**WELWYN HATFIELD BOROUGH COUNCIL
EXECUTIVE DIRECTOR - PLANNING, PUBLIC PROTECTION AND GOVERNANCE**

DELEGATED APPLICATION

Application No: 6/2019/2953/HOUSE
Location: 67 Eddington Crescent Welwyn Garden City AL7 4SX
Proposal: Erection of a single storey side extension
Officer: Mr Tom Gabriel

[01] PROPOSED GROUND FLOOR PLAN

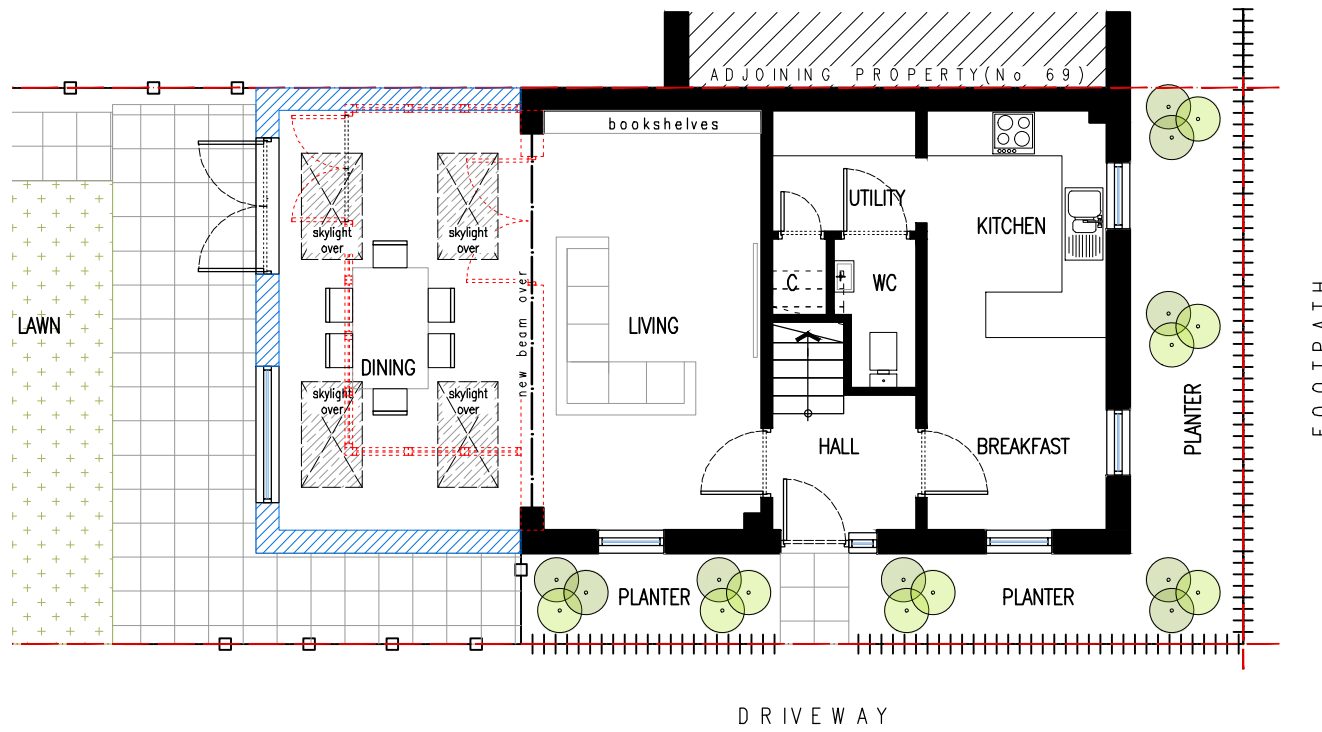
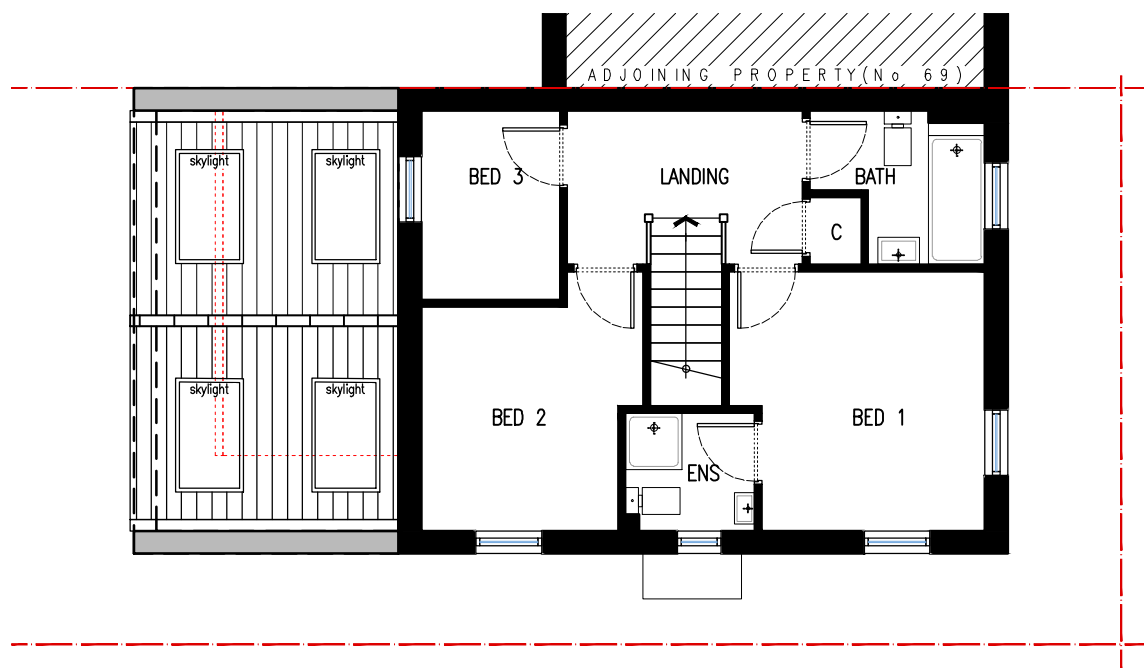
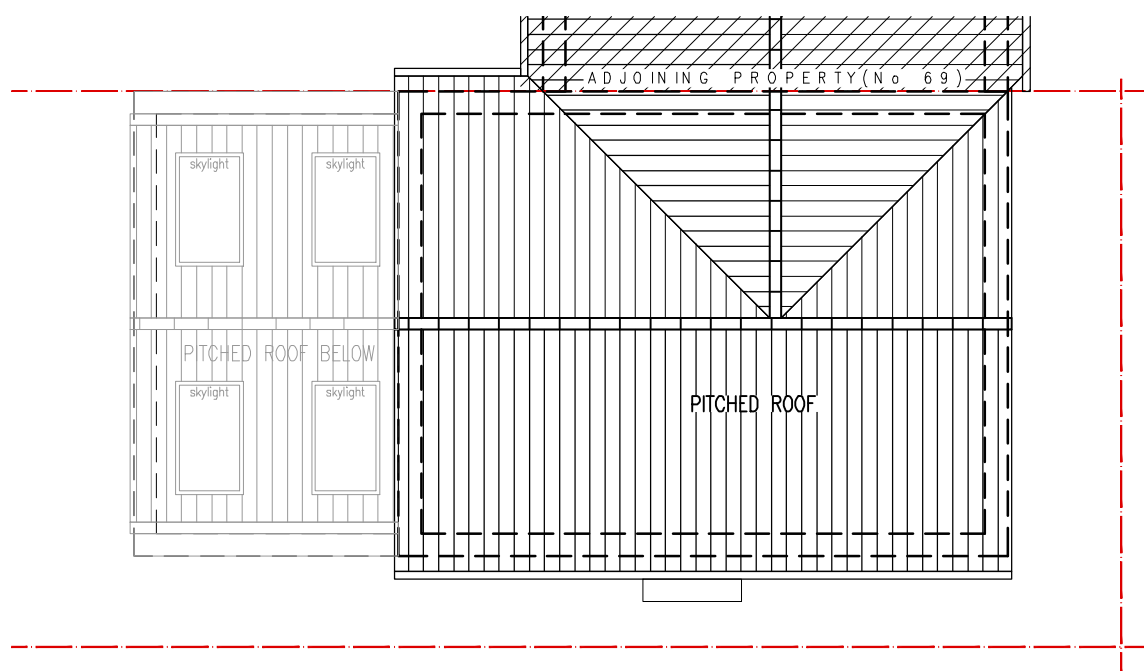
Comment (if applicable): Though the extension would be 3.5m deep on the boundary with 69 Eddington Crescent and would project to the rear of this dwelling by 5.3m in total given the step between the dwellings, as the extension would be 2.7m high on the boundary with 69, it would, on balance, have an acceptable impact upon the outlook and amenities of the occupiers of that dwelling. Sited to the north east of 69, the proposed development would not have an adverse overshadowing impact for 69.
